Recommendation Report for Planning Permission for Works or Extension to a Dwelling

REF NO: AW/100/20/HH

LOCATION: Southgate
Lincoln Avenue
Aldwick
PO21 3EJ

PROPOSAL: Loft conversion with hip to gable extension & dormer, single storey rear & side extension & render & cladding to extension.

ROOF PLAN
PROPOSED
1:50 @ A1

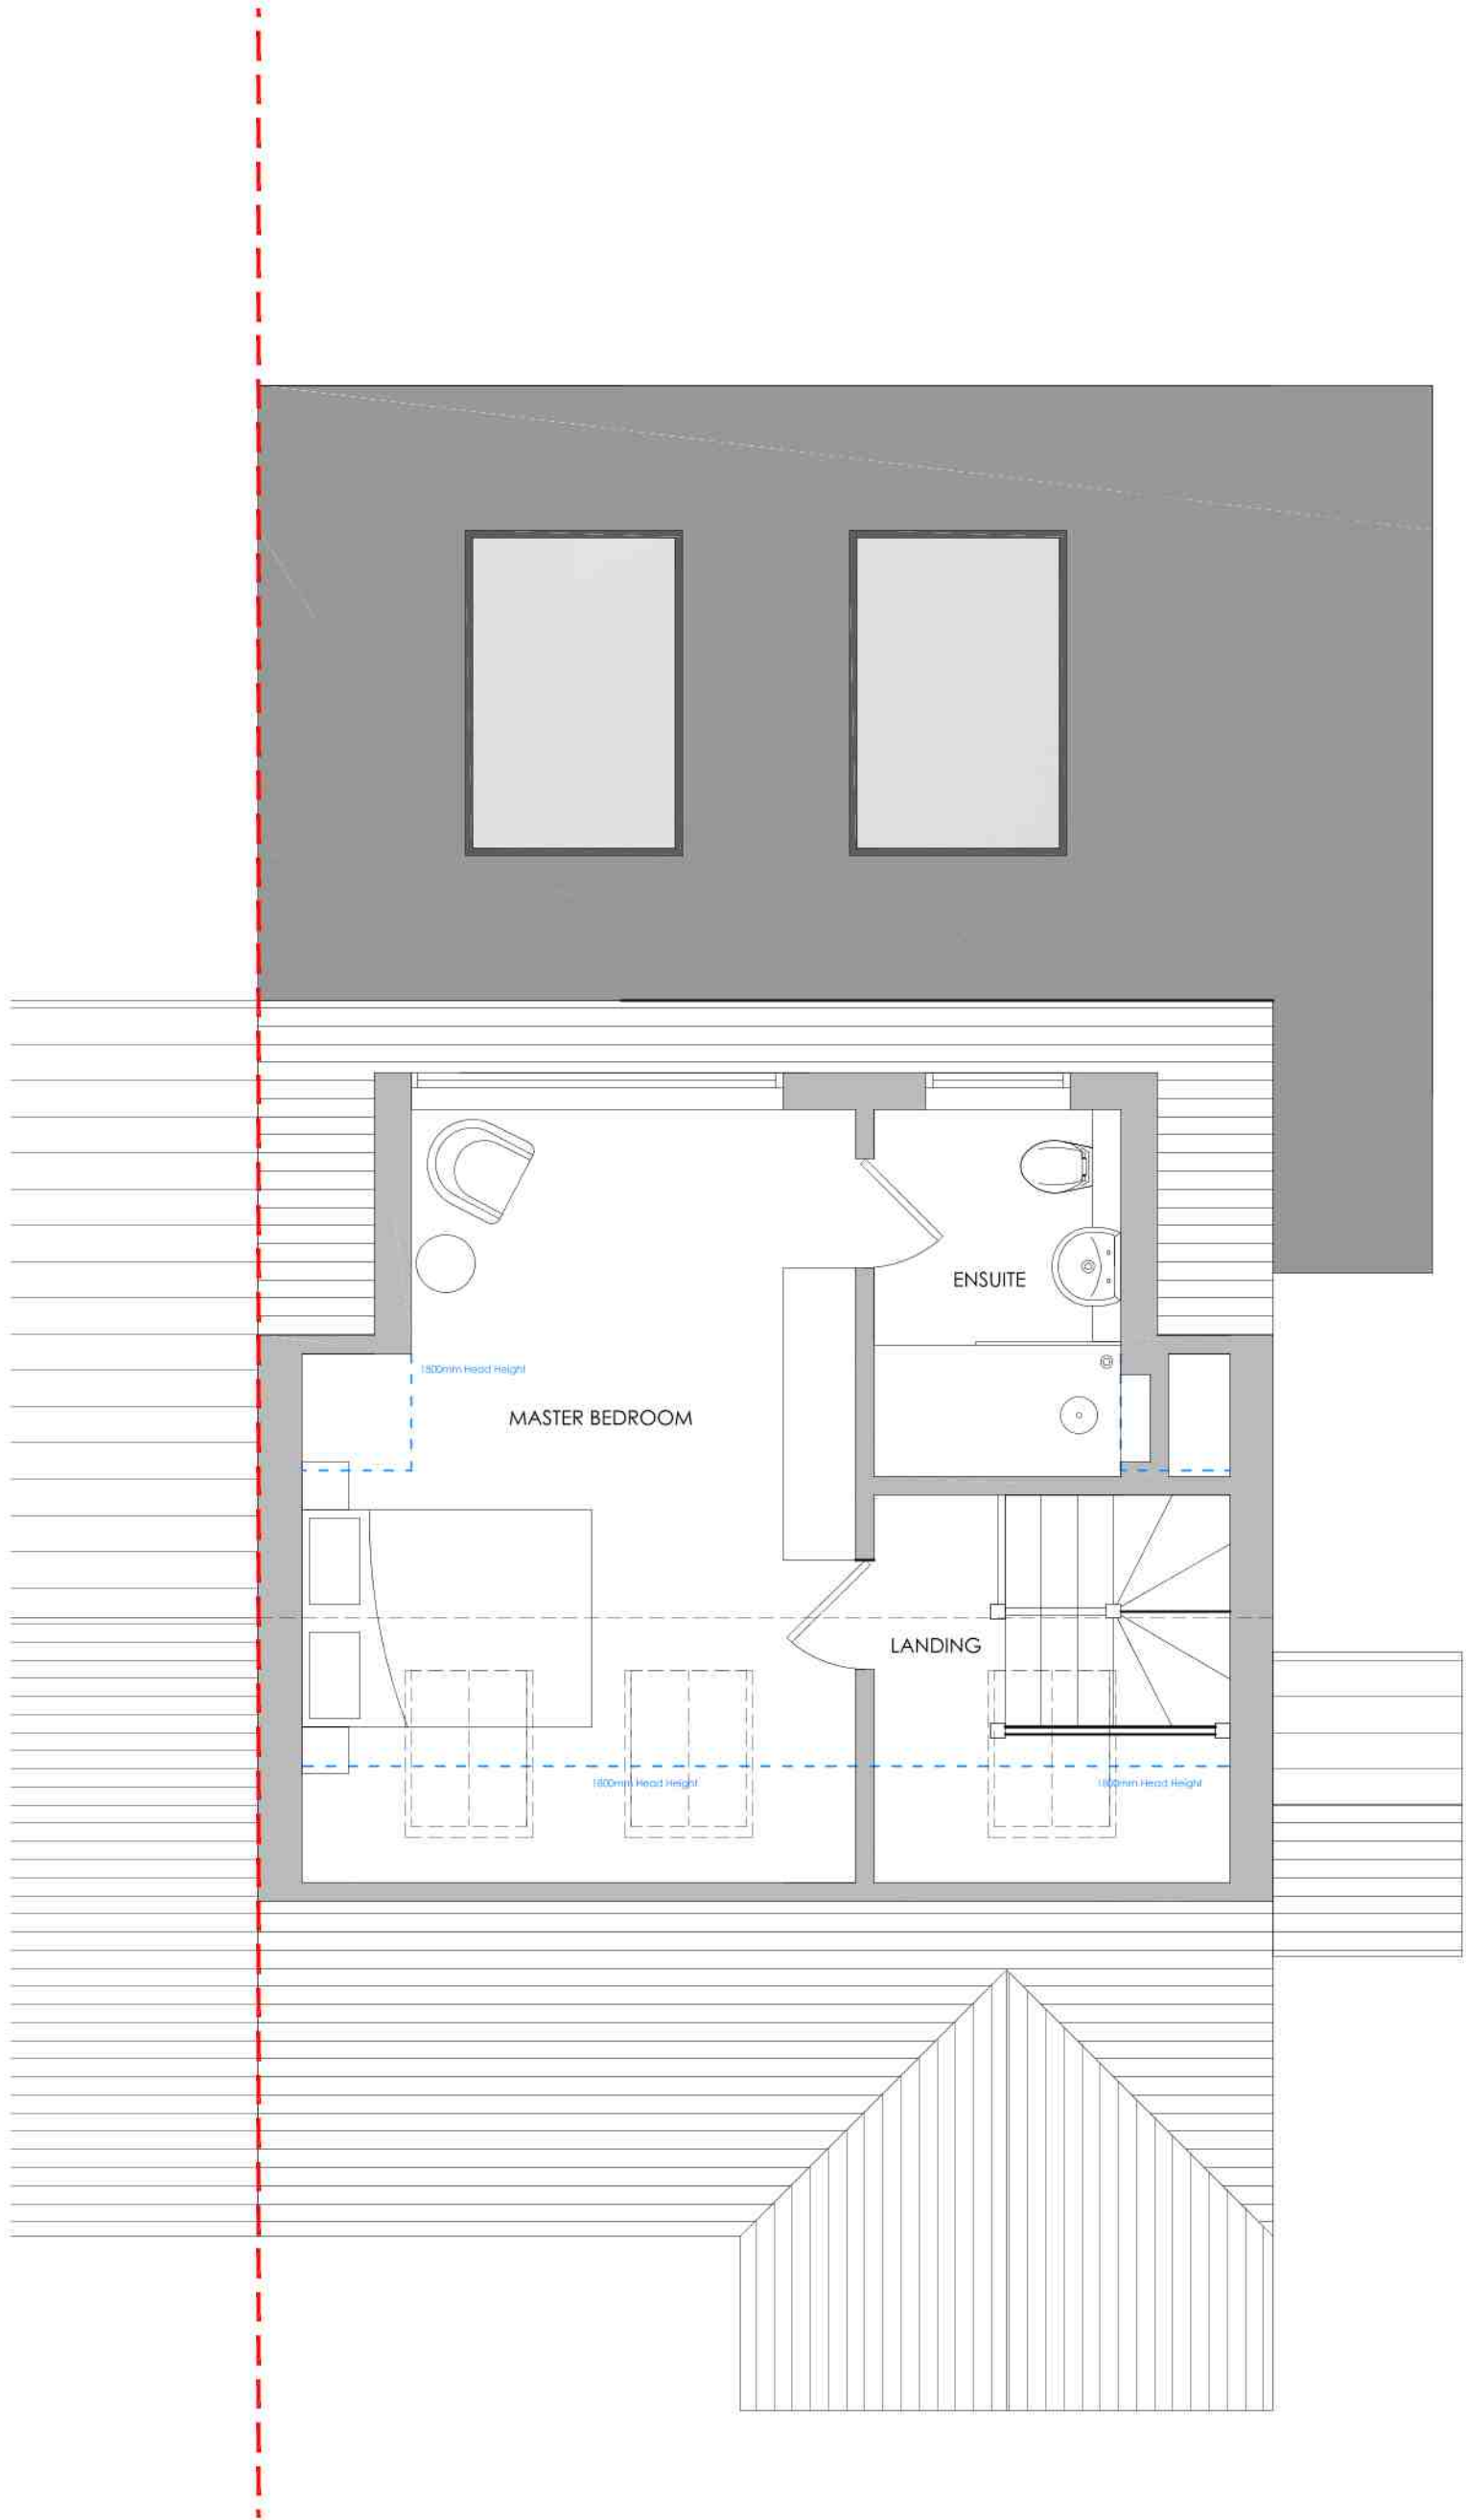
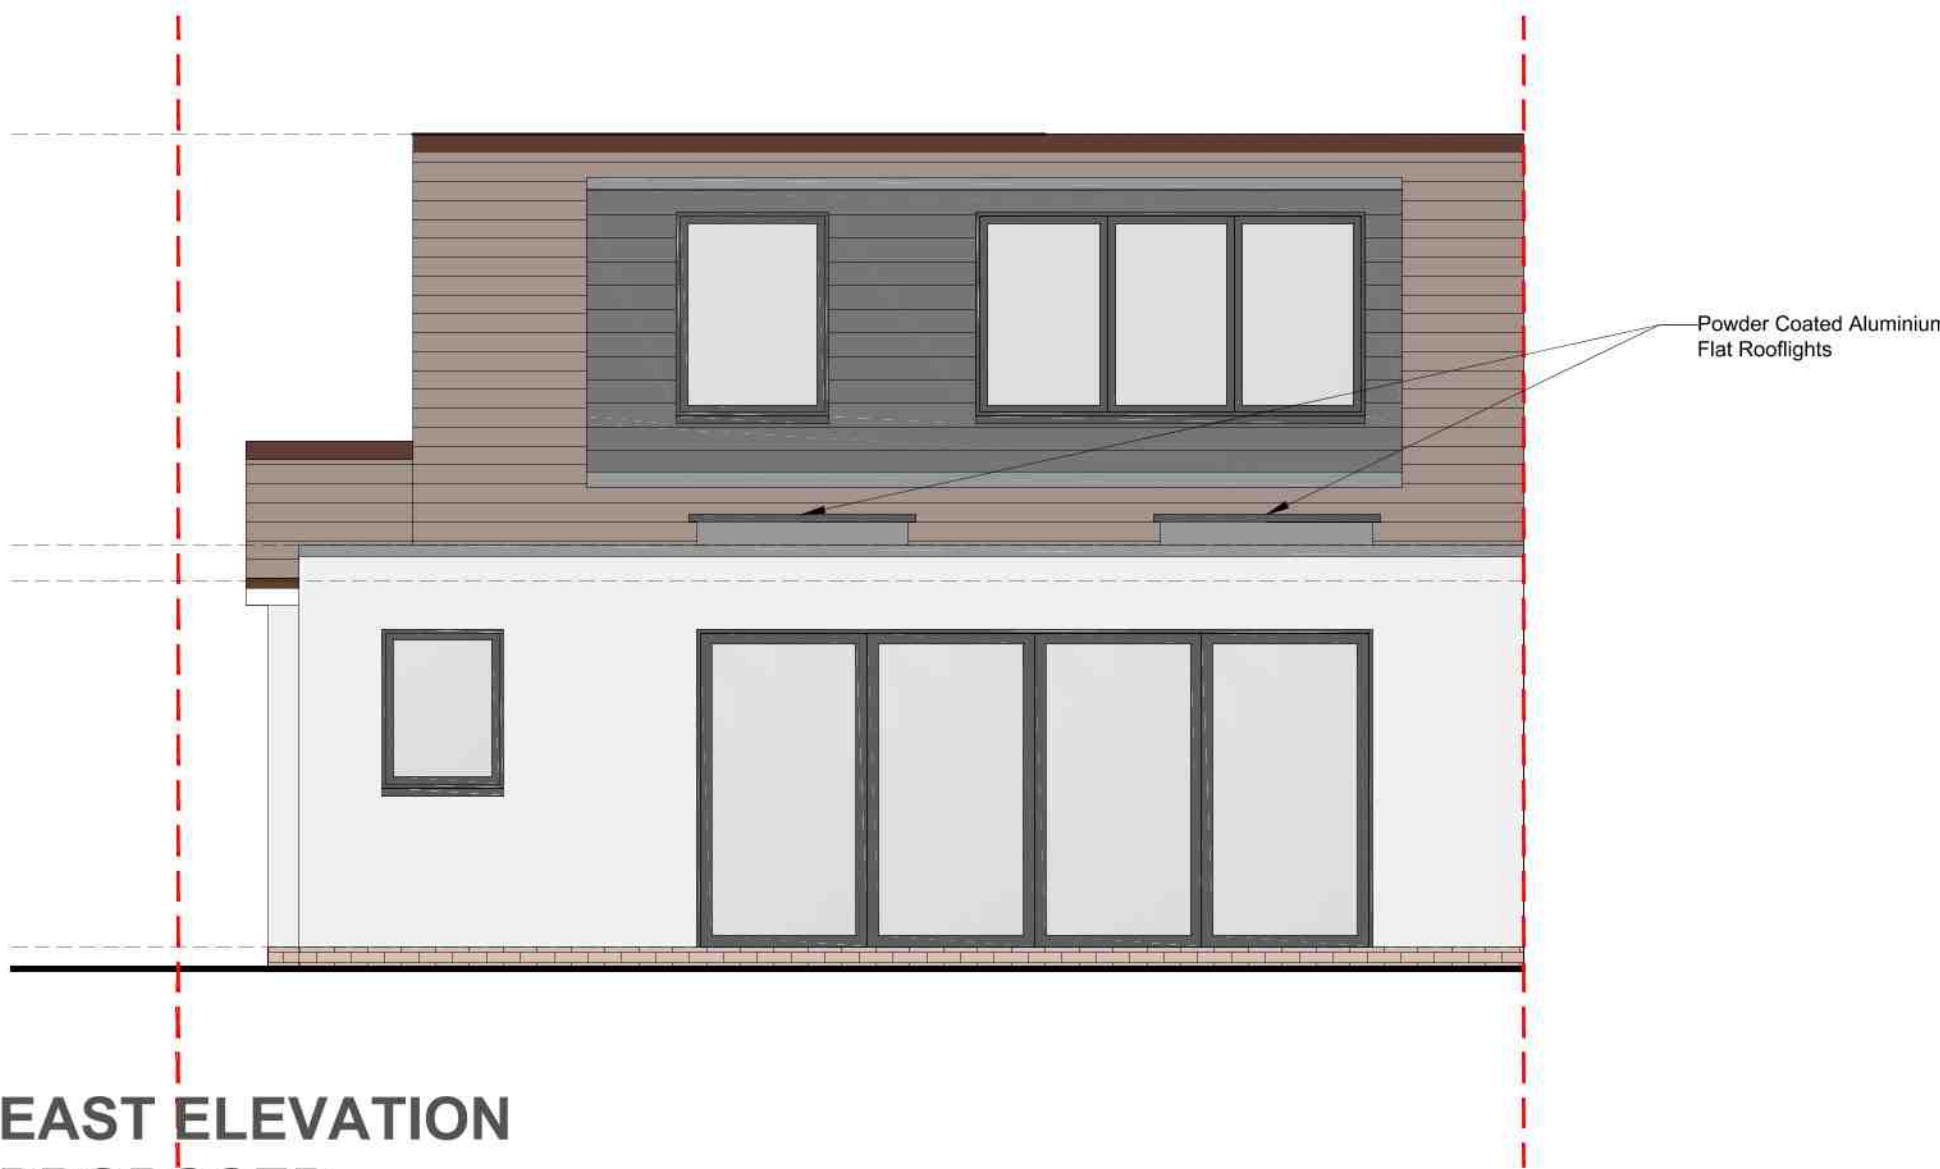
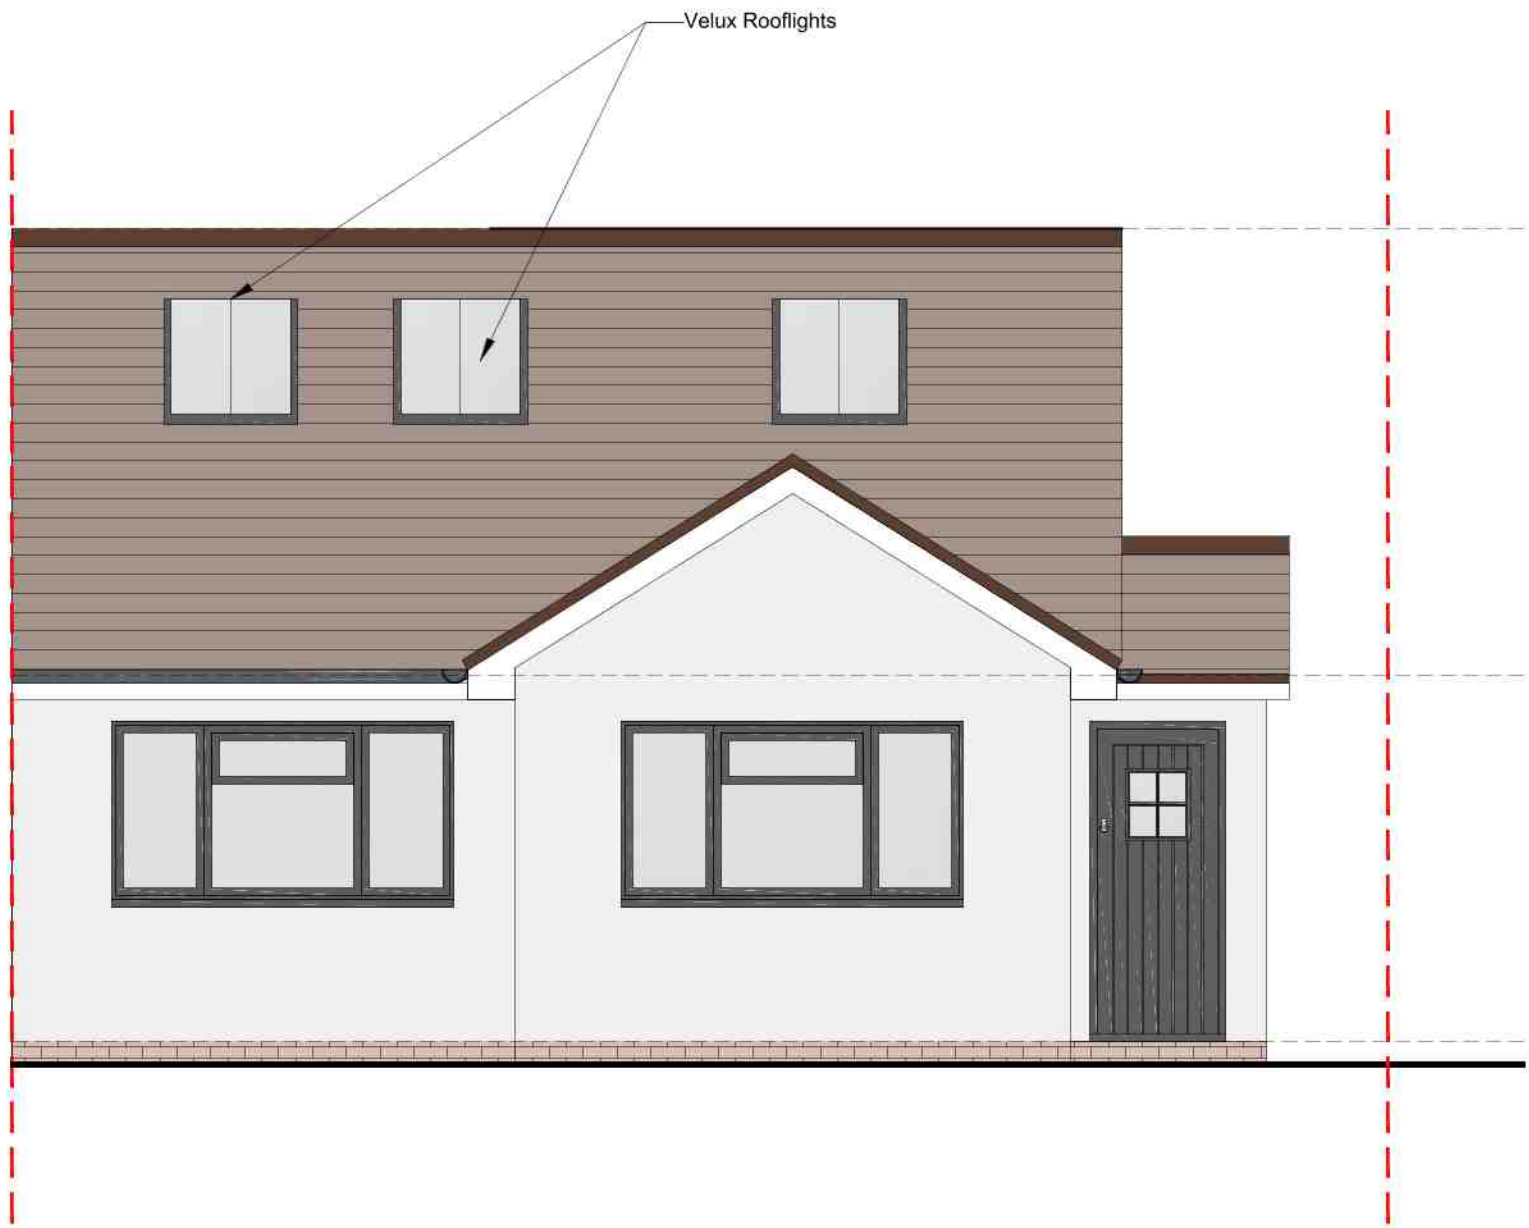
The proposal will alter the roof from hipped to a gable. The dwelling is constructed as a pair with the property to the north and the appearance will contrast this, however surrounding properties, whilst single storey vary in design with some examples of gables roofs and the alteration is not considered to result in the dwelling appearing significantly out of character for the area.

The alteration to the roof increases the ridge height by around 0.1m and due to the minor change, it is not considered to result in an adverse impact.

There is a lean to structure to the south elevation. This will be removed and replaced with a porch, which is well integrated and minor in nature.

Materials consist of clay roof tiles which match the dwelling and render. Cladding will be used to the side gables and rear however visibility of this is limited and the materials are acceptable.

The proposal will alter the roof design from hip to gable which will slightly increase height of the dwelling by around 0.1m. Due to the minor increase, it is not considered to result in the dwelling overbearing or overshadowing upon neighbouring amenity.

There will be the addition of a rear extension. There is a small gable projection to the rear of around 1.2m depth. This will be removed and replaced with an extension which runs along the full rear of the dwelling with a depth of 4.25m and extending beyond the side elevation by 1m and wraps around to the southern side with a depth of 1.85m. The extension will have a flat roof with a height of 2.7m.

This is considered to intersect a 45 degree angle when drawn from the neighbouring window closest to the shared boundary. However a 3m extension could be constructed under permitted development which is also considered to intersect this and the additional depth is not deemed to give rise impacts significant to that which would be permitted. The neighbouring property has provided no objection to the scheme. It is not considered to provide adverse overbearing or overshadowing impacts.

A rear dormer will be constructed. This is fairly modest in size retaining around 0.8-1m to the side elevations of the roof slope. This will have a depth of 3.1m and height of 2m and is not considered overbearing with the development retained within the existing roof slope. The windows will provide additional overlooking to neighbouring properties but not significantly above that which could be achieved as permitted development.

There will be doors to the rear and an additional window to the south elevation. With these at ground floor level, it is not considered to give rise to adverse overlooking with sufficient fencing in place also.
